Your Ref: OWPC20146
Our Ref: FP/201/18/PL
Please ask for:
Mr R Castro-Parker

1 No. dwelling.
Mermaid And Playbox Sea Road Felpham

Thank you for your internet comments made on 10th October 2018 which has been recorded as **'an objection'** with the comments as follows:

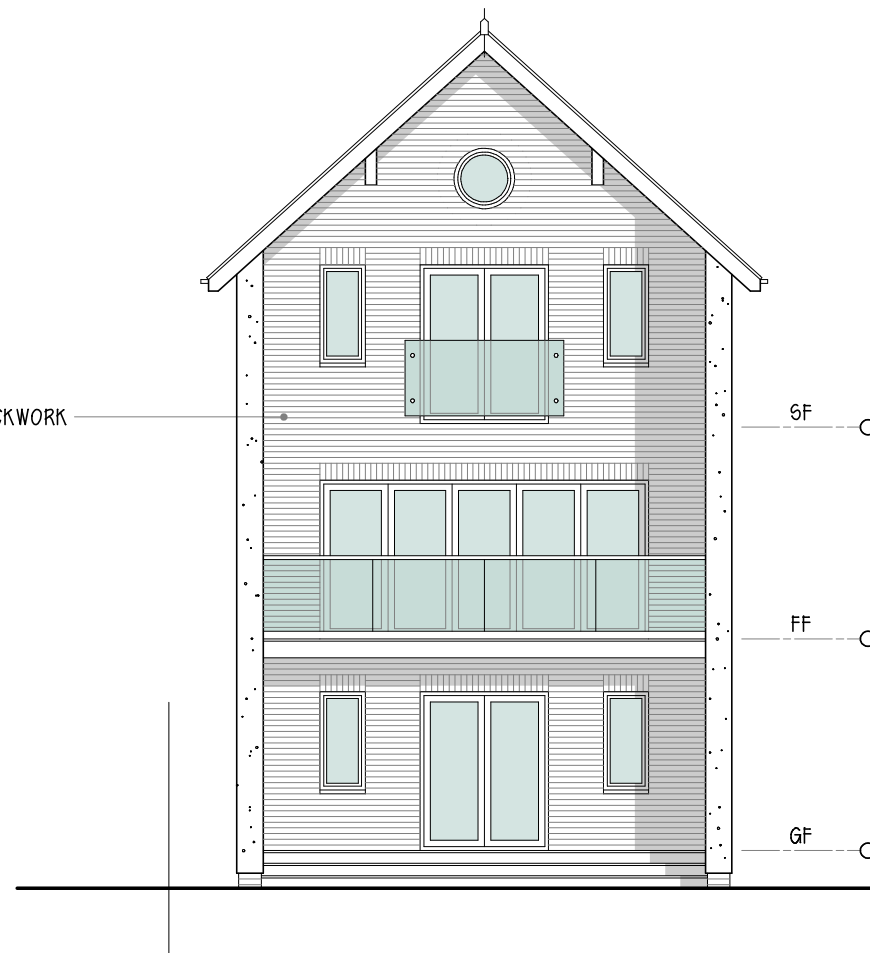
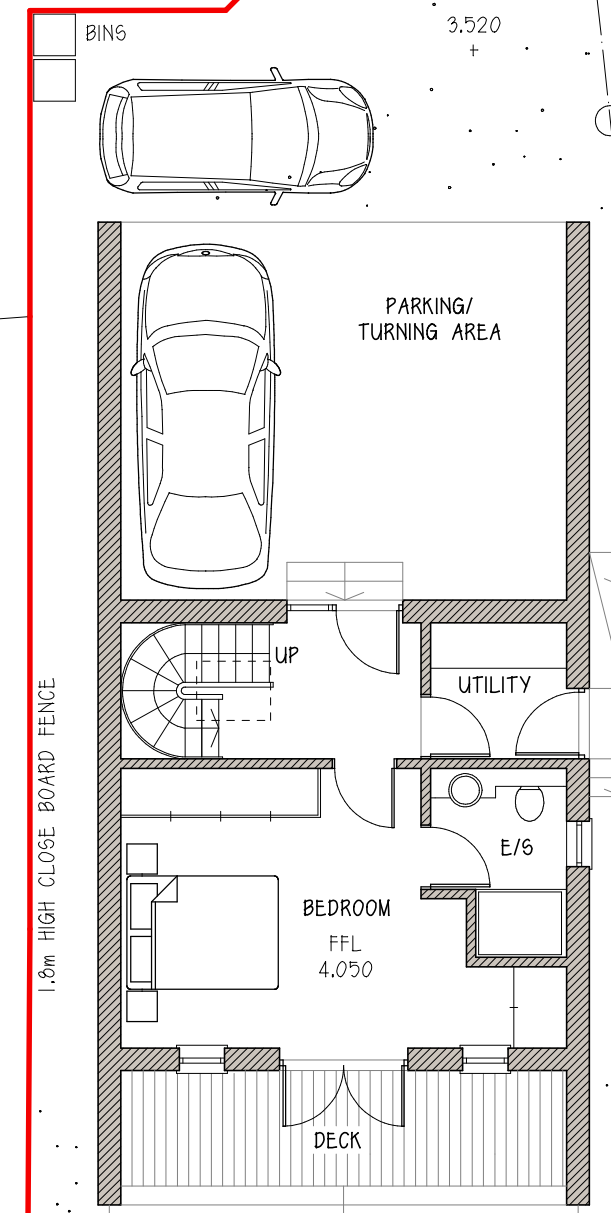
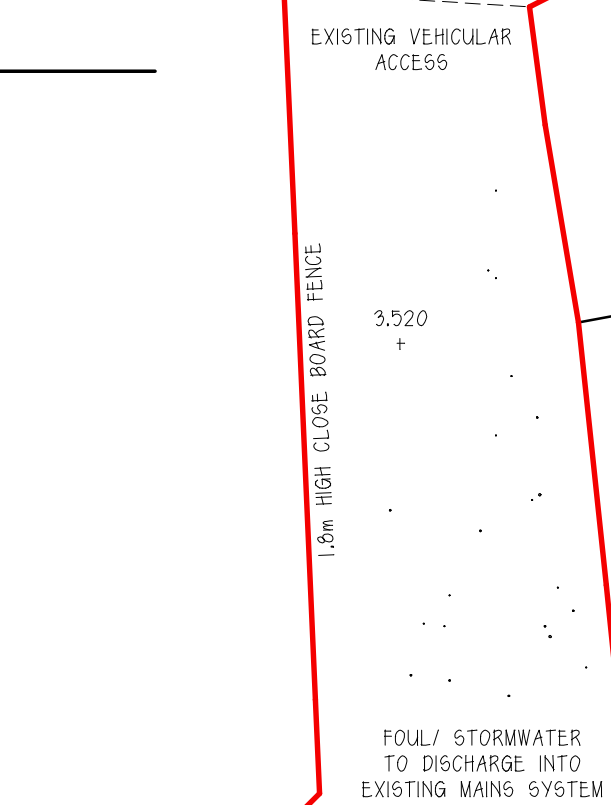
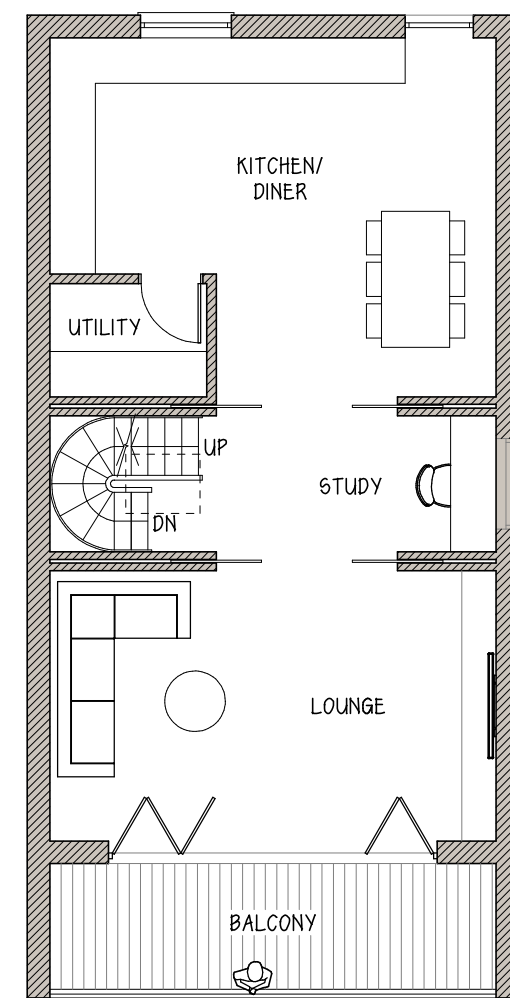
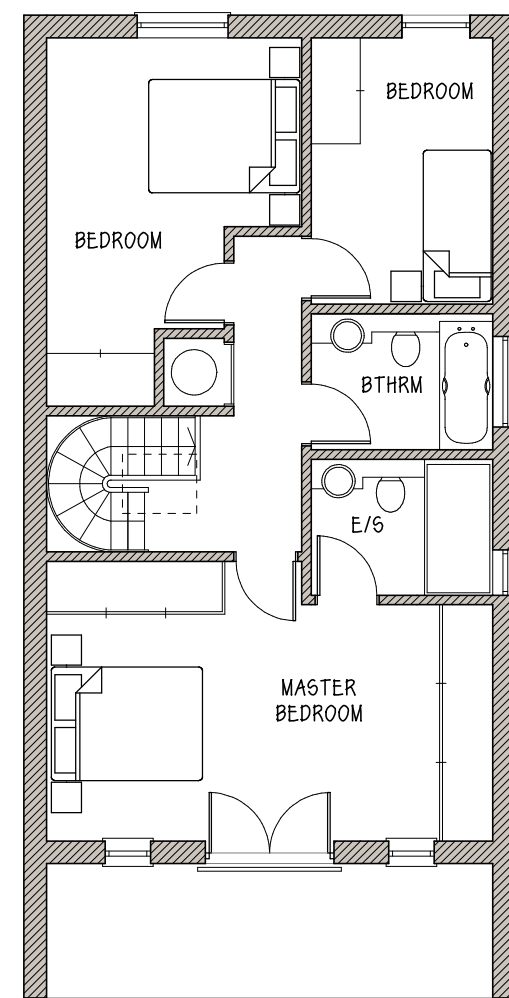
Objection - out of keeping with surrounding properties (3 storeys) and concerns over access and egress to the site.
